Subject: Comments relating to planning applications FG/129/21/PL 2 The Poplars, Ferring, BN12 5QL

I agree to the application of a new detached dwelling of 2 The Poplars, Ferring with one concern.

DRAWING TITLE	PROJECT NO.	DRAWING NO.
Proposed Elevations / Section AA	21001	GE.01
STATUS	DATE	REVISION
PLANNING	07.21	-

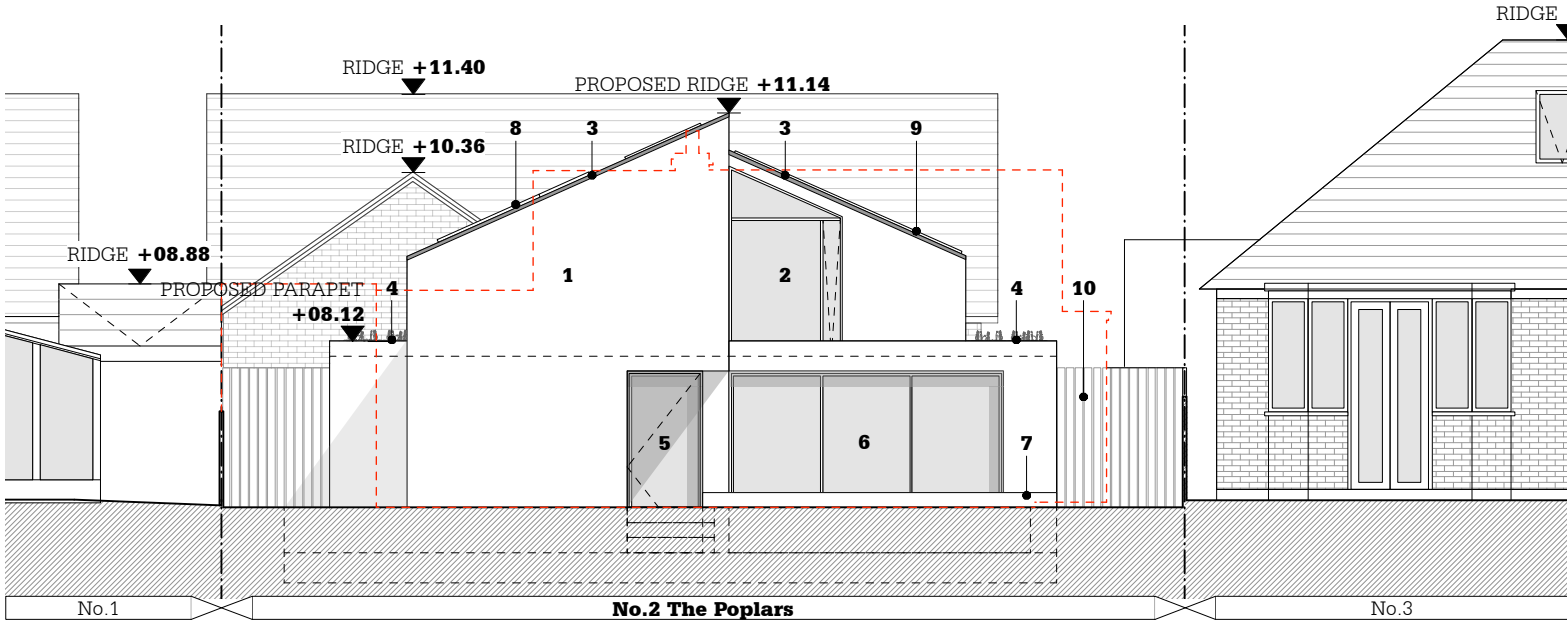
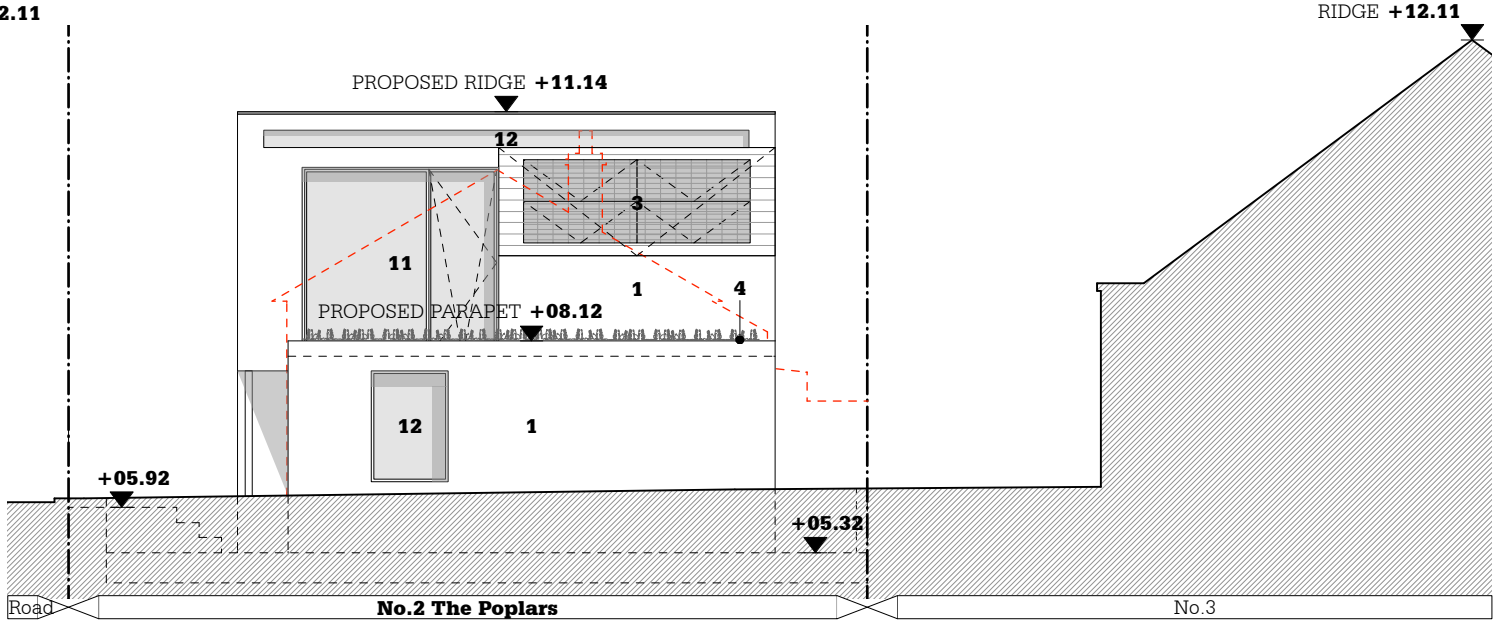
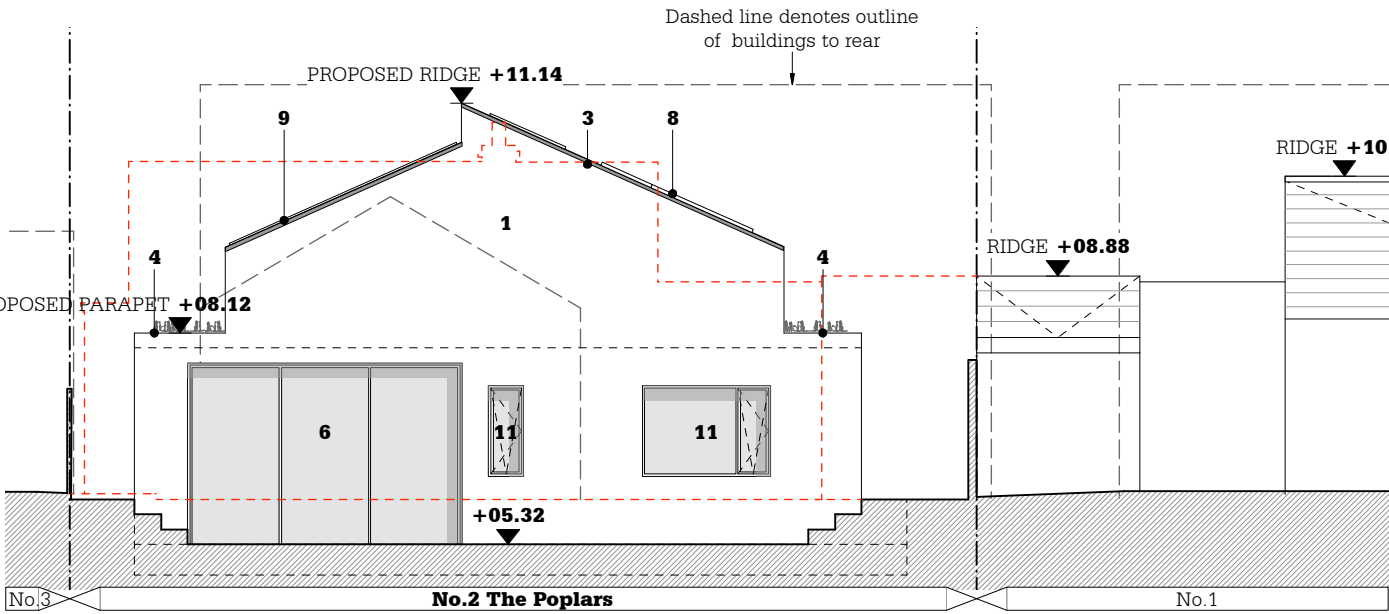
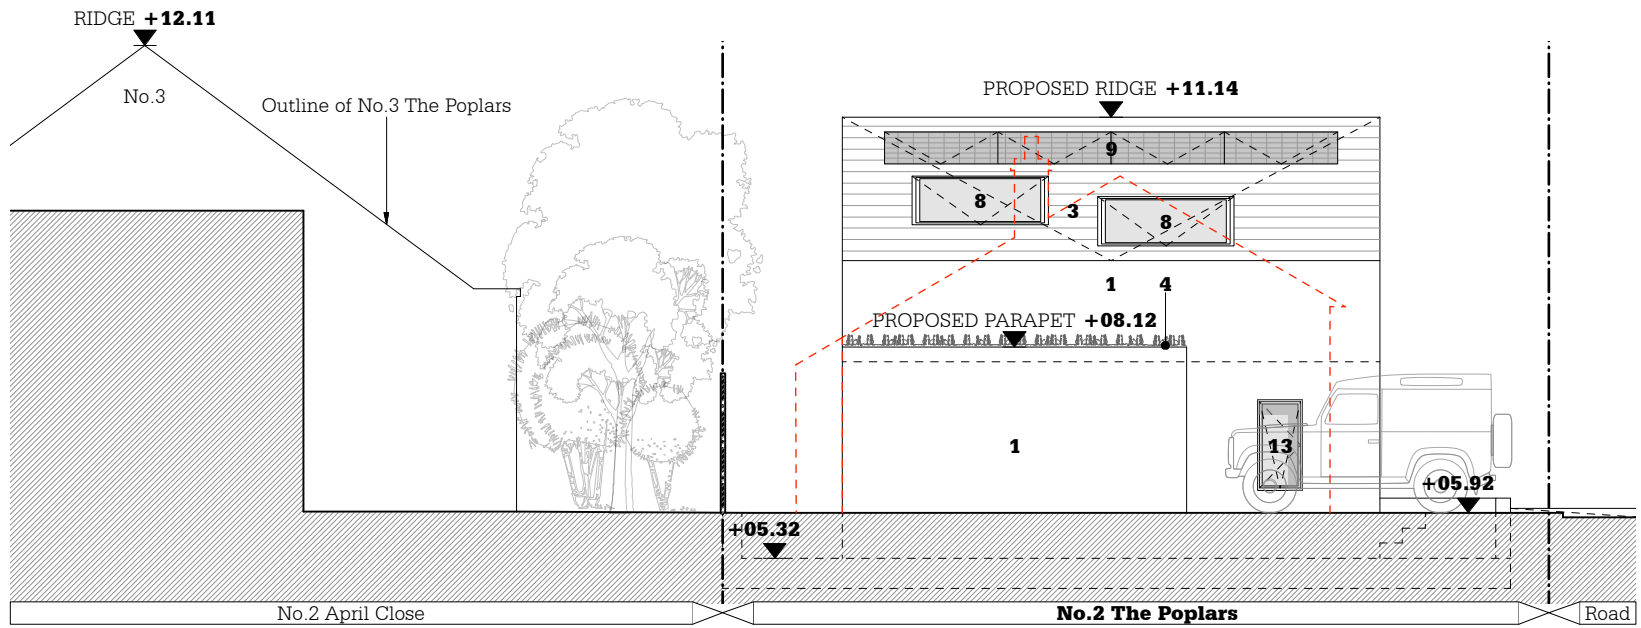
The only concern I have is about the 'planted roof' on the first floor becoming a balcony in the future.

Could you please add a planning condition which is to prevent it being used as a balcony for recreational use as this would have a huge detrimental impact on my overall privacy.
